**WELWYN HATFIELD ACCESS GROUP  
HAZEL GROVE COMMUNITY CENTRE  
HAZEL GROVE  
WELWYN GARDEN CITY  
HERTFORDSHIRE AL7 2DG**

**re: Planning Applications Received by Welwyn Hatfield Council**

<b>Application No.</b>	<b>Description and Location</b>	<b>Applicant/Agent</b>
S6/2013/1785/FP	Change of use from existing B1 (Office) to four residential flats with retention of class A1 (Retail) on part ground floor, with associated internal and external alterations  Chequers House 1-5 Park Street Hatfield AL9 5AT	Ms K Crowder-James Contour Planning Services Weltech Centre Ridgeway Welwyn Garden City AL7 2AA

Proposed Plans

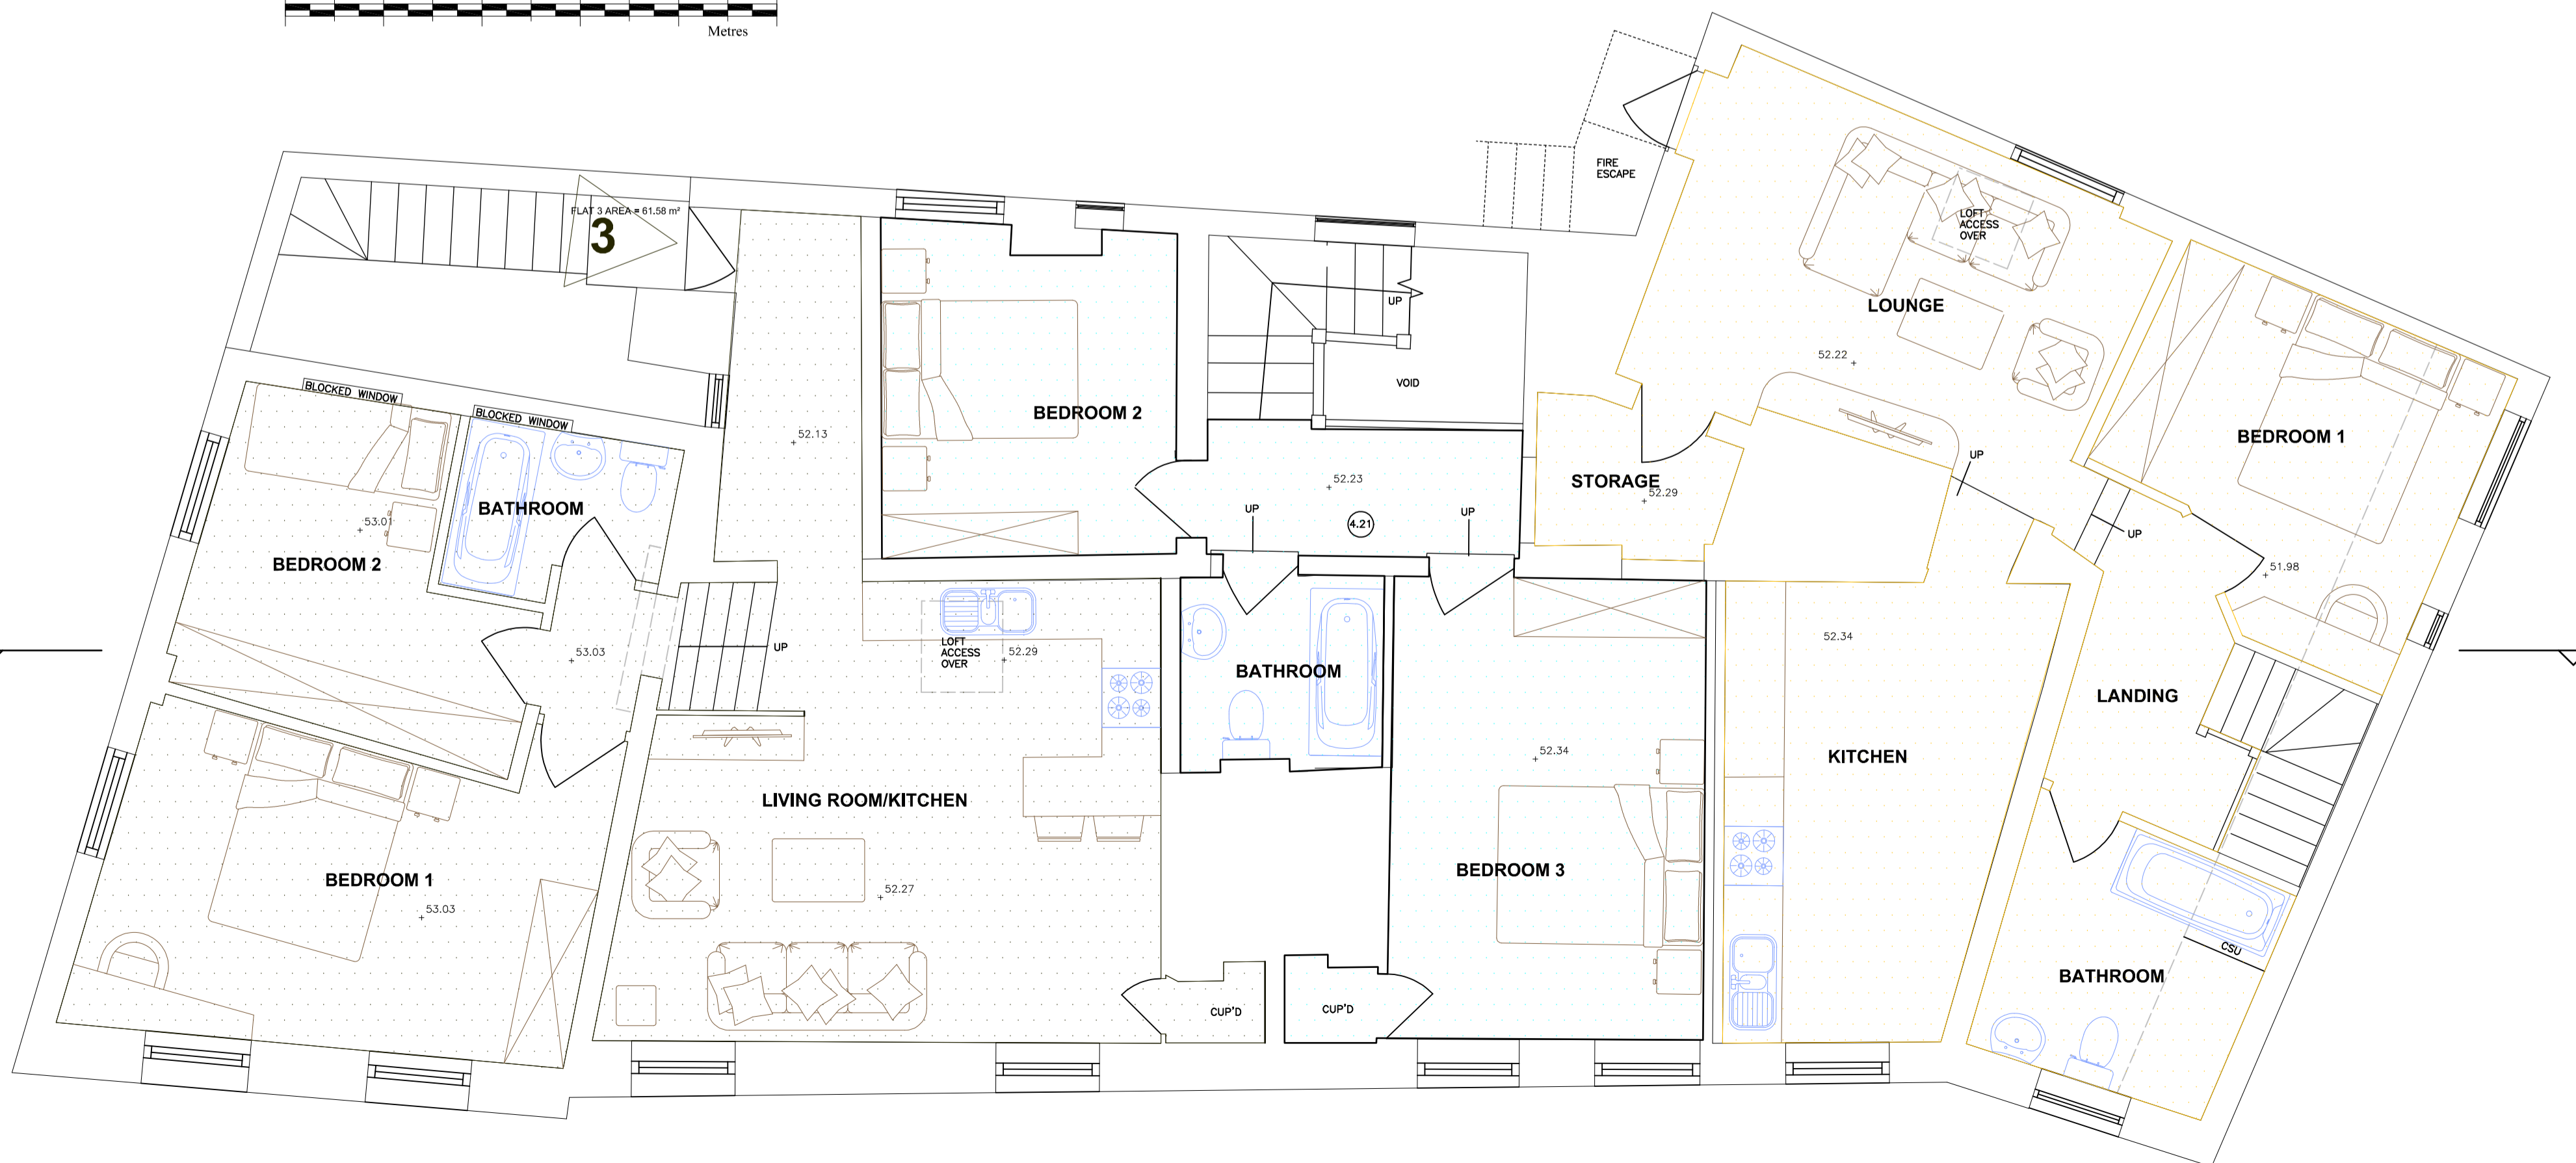
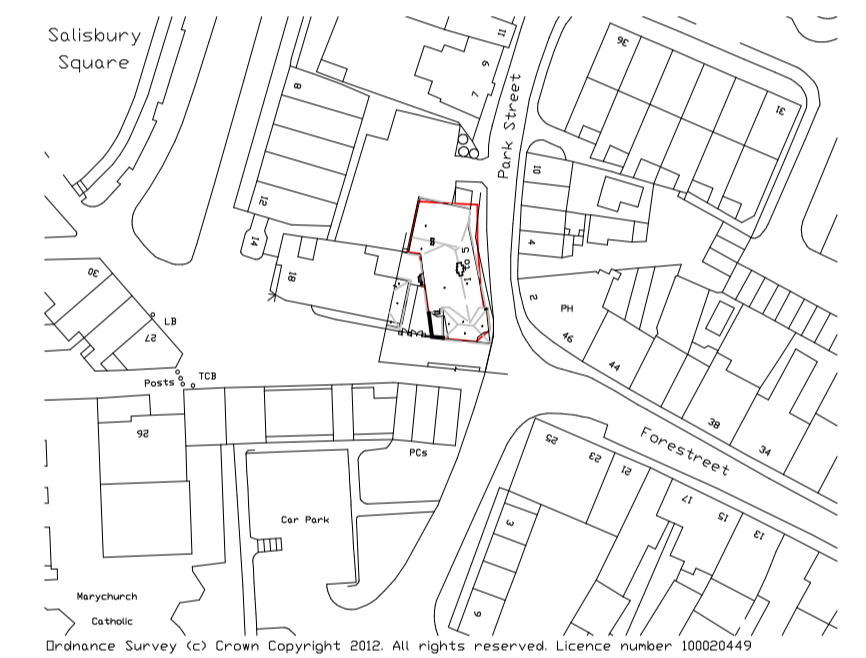
We note the details provided by this drawing. Could you kindly confirm there is level entry at all a principal ground floor entrance?
